CITY OF ALBUQUERQUE

January 23, 2017

**RE: Lot 29 Block 8 Unit 22 Volcano Cliffs SAD 228
6401 Picardia NW
Grading and Drainage Plan
Engineers Stamp Date 1/19/17 (D10D003E29)**

ENGINEER'S SEAL  1/16/17 DAVID SOULE P.E. #14522	LOT 29, BLOCK 8, UNIT 22 VOLCANO CLIFFS	DRAWN BY JDG
	GRADING AND DRAINAGE PLAN	DATE 01-15-2017
 1606 CENTRAL AVENUE SE SUITE 201 ALBUQUERQUE, NM 87106 (505) 872-0999		SHEET # 1 OF 1
		JOB #

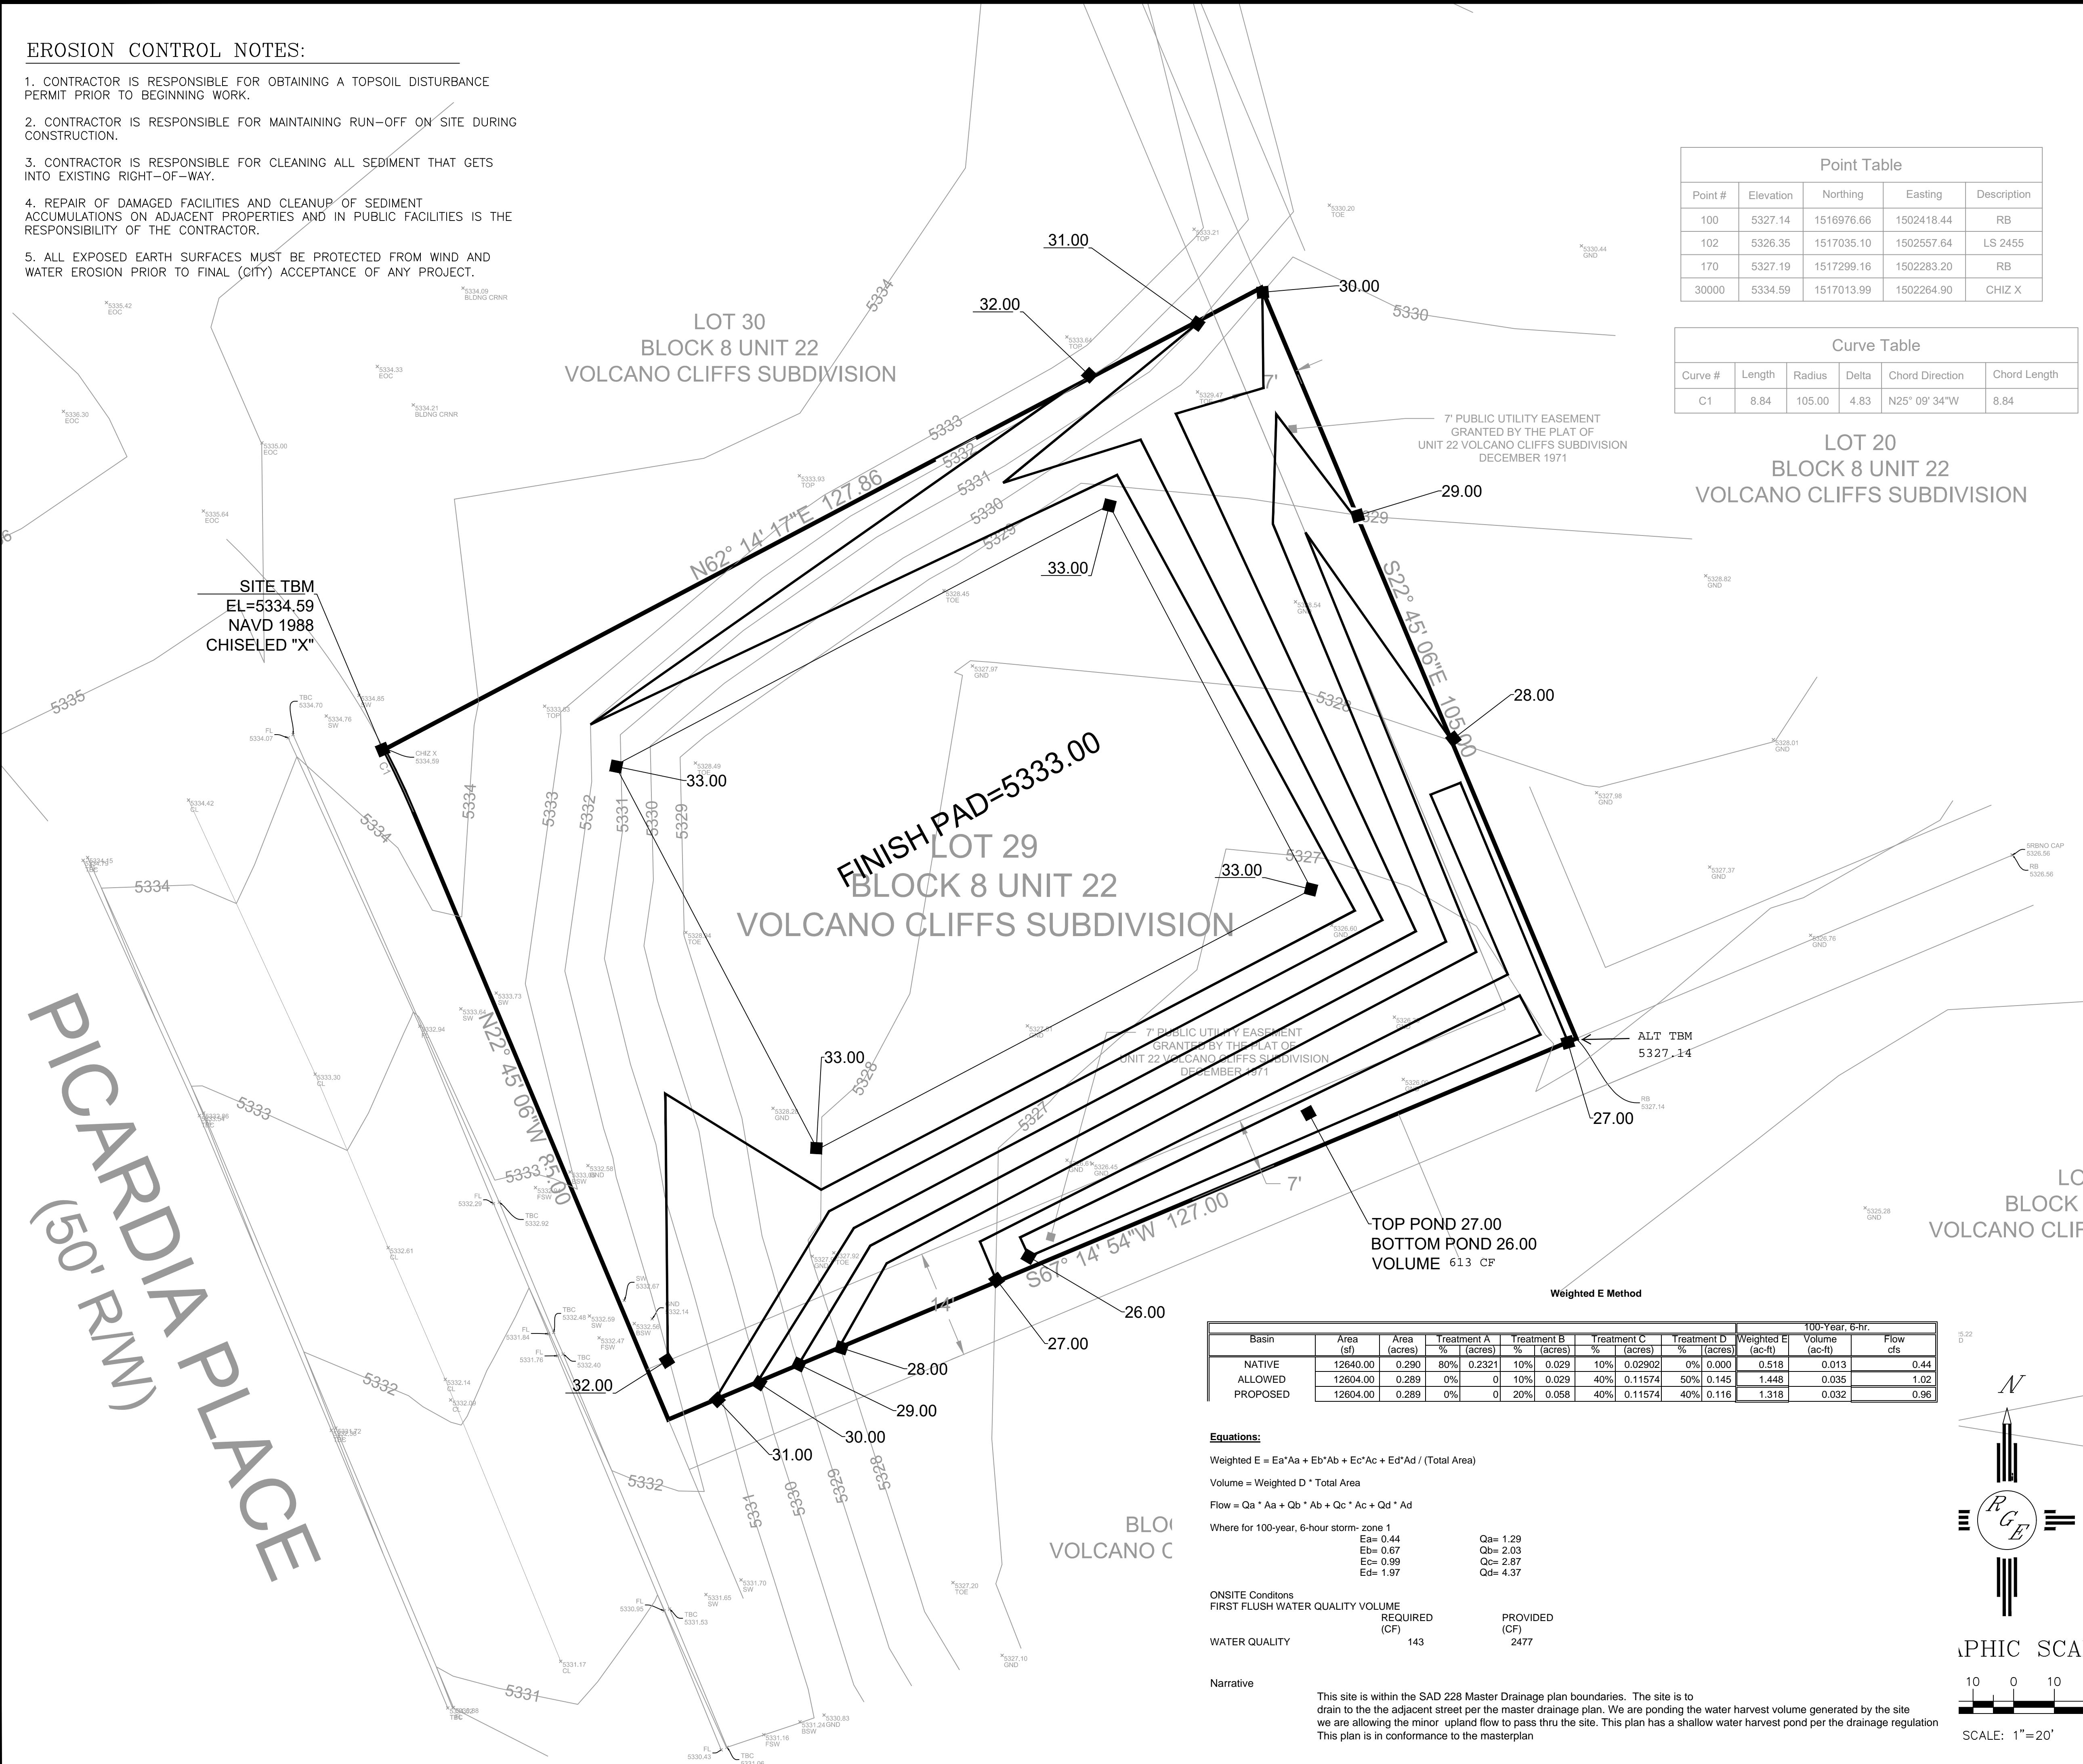
Based upon the information provided in your submittal received 1/17/17, the above referenced Grading and Drainage plan dated 1/16/17 cannot be approved for Grading Permit until the following comments are addressed:

- Provide a note stating that future garden walls require a separate permit and this plan should be used for their placement. We have added note
- Also state that future garden walls require an opening 3" above grade in the NW corner and SW corner. We have added note
- Provide a note stating retaining walls are not allowed in the rear yard unless a swale is provided so flows may pass from the property to the north into their property and to the south property. We have added note
- Provide a statement that a pad certification is required before a building permit is given. We have added note
